The Drovers Solar Farm

Statement of Common Ground (SoCG) with Environment Agency (Tracked)

Document reference: APP/5.13.2 (Revision 2)

DRAWING TITLE:
Figure 12.13: Work No. 2 Maximum Potential Foundations and Groundwater Elevations

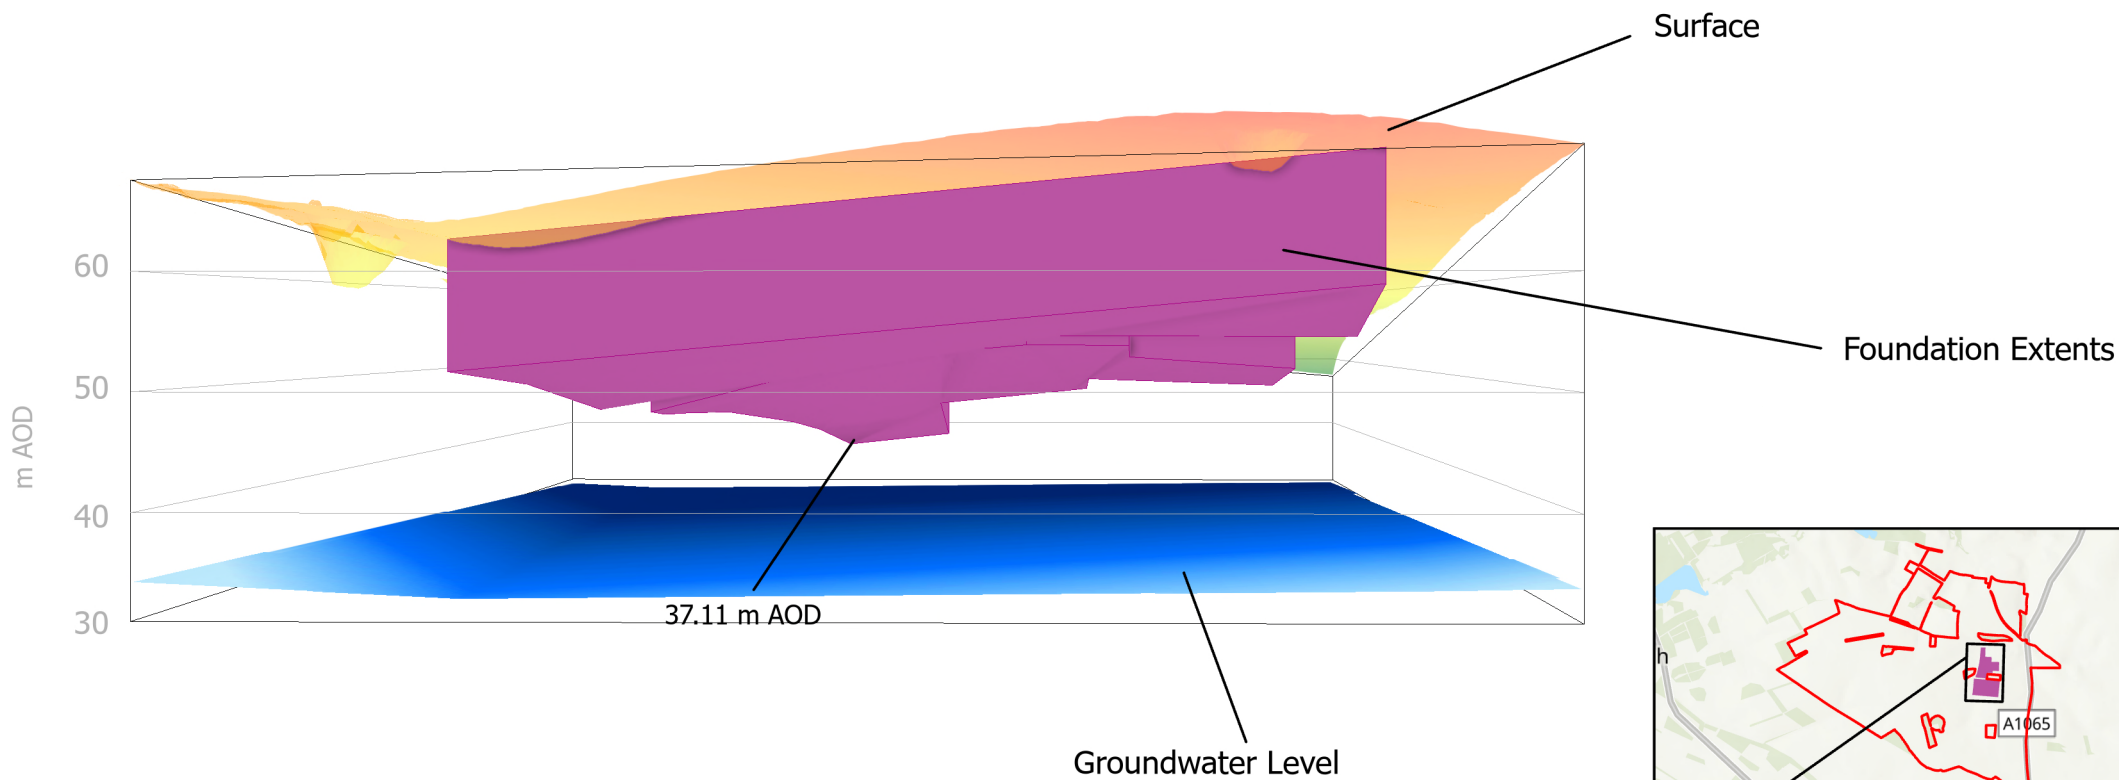
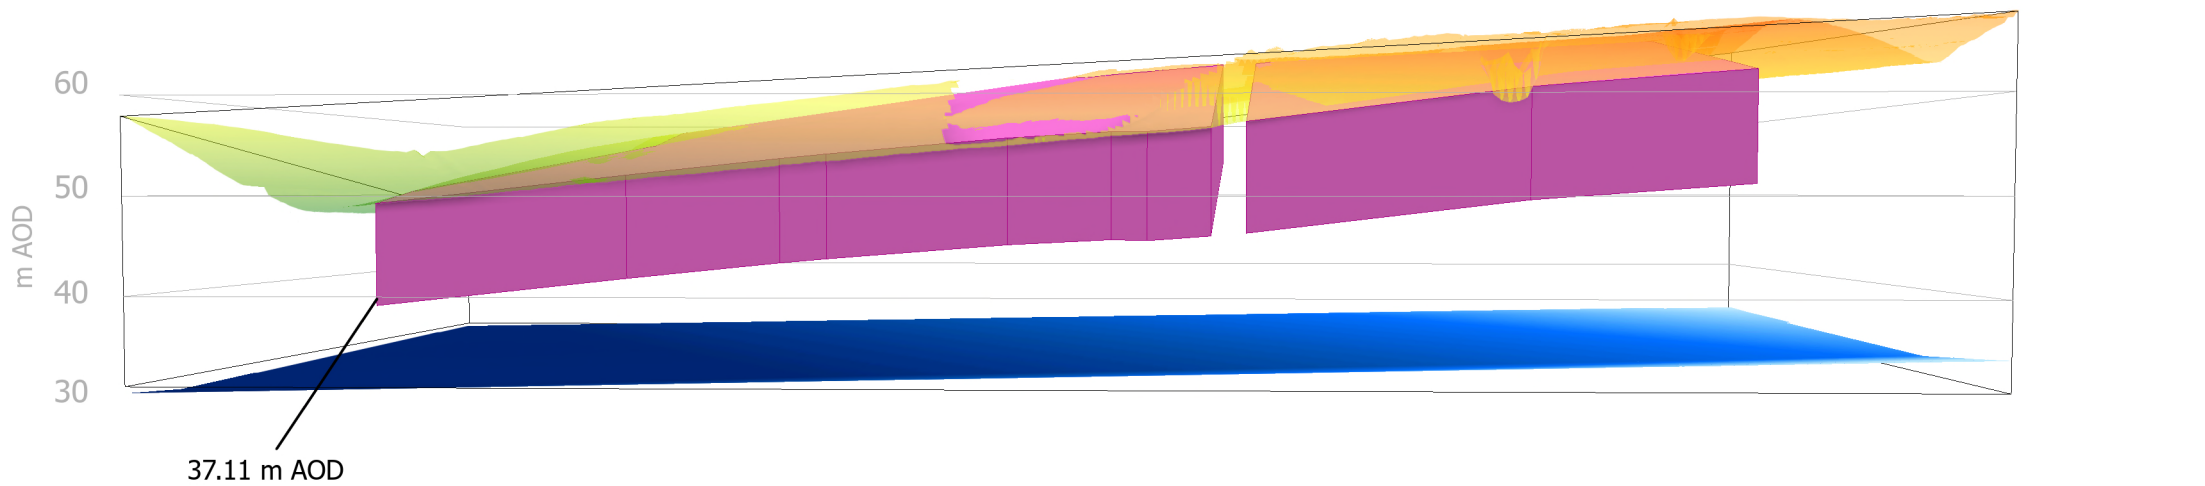
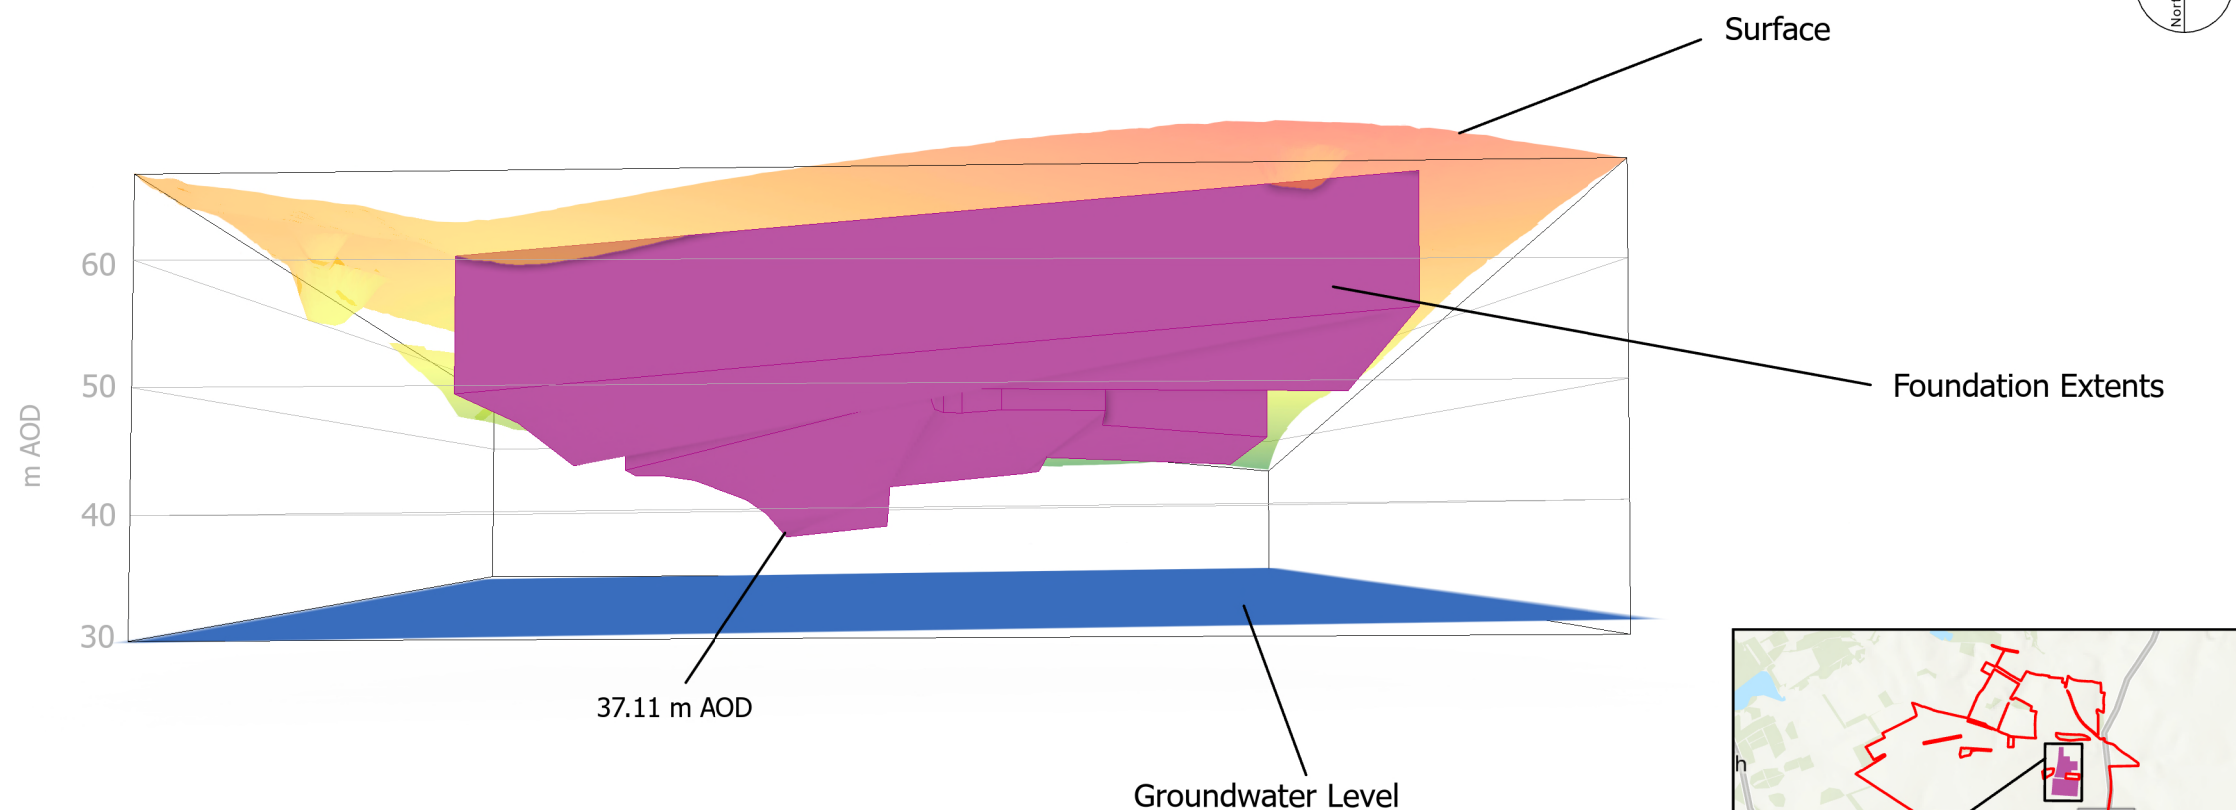
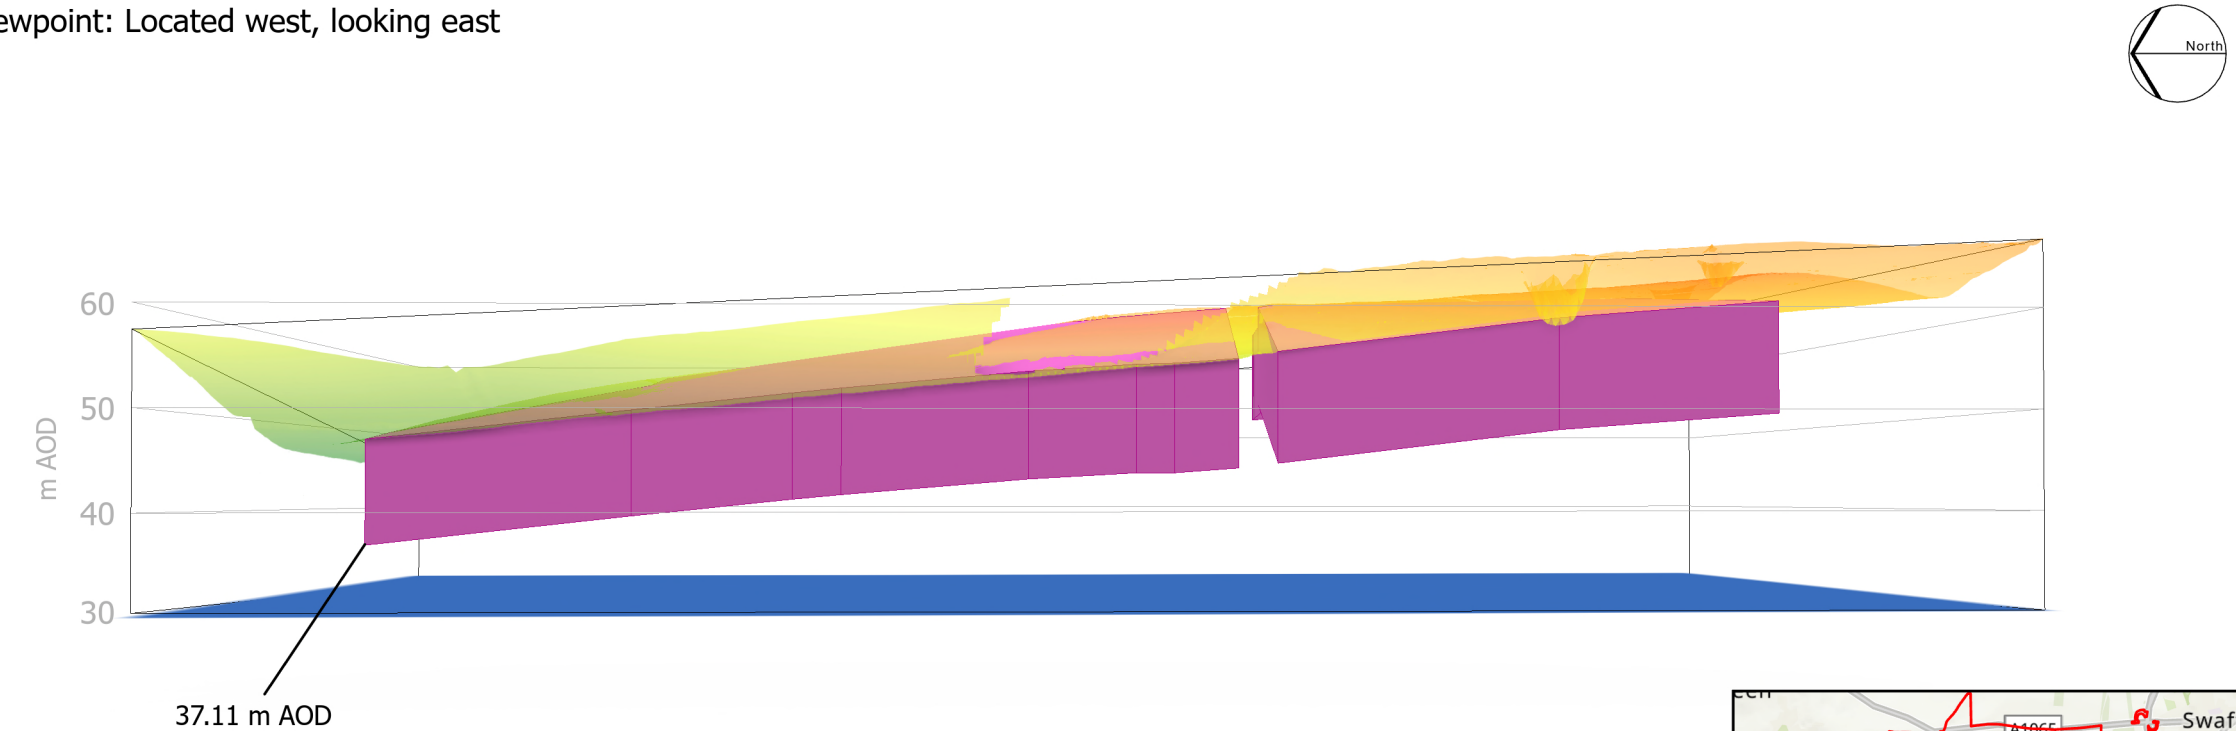
Reference	EA Issue Reference	Topic	Consultee's Position	Applicant's Position	Status
2-1	EA05	Maximum Foundation Extents	Figure 12.13 Work No.2 Piling Locations within CSA for Maximum Groundwater Level [APP-127]	Figures 12.13 to 12.16 of ES Chapter 12: Water Resources [APP/6.2.3APP-061] were used to illustrate the maximum groundwater elevation surface across the Core Study Area and identify where	Medium Agreed

report should preferably refer to groundwater 'elevation' (in mAOD) as is represented within the figures rather than 'level', which could be misinterpreted as relative to ground level rather than Ordnance Datum. Figure 12.16 shows the minimum (i.e. deepest) groundwater elevation (i.e. best case) in relation to anticipated piling depth. Although this is useful information, this could potentially be misinterpreted by the reader as presenting a combined overview of the information provided in Figures 12.13 to 12.15. We are satisfied and consider this issue resolved. We were concerned that figures 12.13 [APP-127], 12.14 [APP-128], 12.15 [APP-129] and 12.16 [APP-130] do not clearly define the area represented by the drawings, including view orientation, or the elevation values. We have reviewed the following: • 6.3.1 ES Figure 12.13 Work No. 2 Maximum Potential Foundations and Groundwater Elevation [REP3-043] • 6.3.1 ES Figure 12.14 Work No. 3 Maximum Potential Foundations and Groundwater Elevation [REP3-044]	Parameters Commitments [APP/5.8.34] have been<u>was</u> updated at Ddeadline 2 to commit to foundations not directly interacting with groundwater. <u>The Applicant maintains the position that a potential interaction of up to 1 m has been determined for a very small section of Work No. 4 and that Figure A12-1-10 displays this minimal interaction northeast of Work No. 4, should the full Work No. be developed.</u>

• <u>6.3.1 ES Figure 12.15 Work No. 4 Maximum Potential Foundations and Groundwater Elevation [REP3-045]</u> <u>We find the updated figures satisfactory for defining the 3D model view, and elevation the maximum extent of the foundations</u>		
2-2	EA38	Storage of Waste Batteries	<u>We are satisfied and consider this issue resolved.</u> <u>We were concerned that there was an absence of mitigation measures relating to the storage of waste batteries.</u> <u>The 7.14.1 outline Battery Safety Management Plan (Tracked) [REP3-072] has been updated to include suitable measures. We cannot resolve this issue. We were concerned that there was an absence of mitigation measures relating to the storage of waste batteries. The Applicant has stated in 8.4 Applicant's Response to Relevant Representations [REP1-067]: "End-of life or damaged BESS units are to be electrically disconnected from the system when identified as being required. When disconnecting damaged or defective units, a specific risk assessment shall be conducted prior to the removal of the defective module to ensure the safety of employees and contractors. Damaged or defective units will be inspected and placed in an approved protective container prior to being</u>	An outline Battery Safety Management Plan (oBSMP) [APP/7.14.2APP-194] has been prepared as part of the DCO Application which sets out the mitigation measures to be secured via Requirement 6 of the draft DCO [APP/3.1.14]. <u>The oBSMP [APP/7.14.2] has been updated at Deadline 4 to confirm the management of damaged or end-of-life batteries by the following:</u> End-of-life or damaged BESS units are to be electrically disconnected from the system when identified as being required. When disconnecting damaged or defective units, a specific risk assessment shall be conducted prior to the removal of the defective module to ensure the safety of employees and contractors. Damaged or defective units will be inspected and placed in an approved protective container prior to being transported from Site, to ensure against any risk of contaminants entering ground- or surface water. End-of-life batteries awaiting	LowAgreed
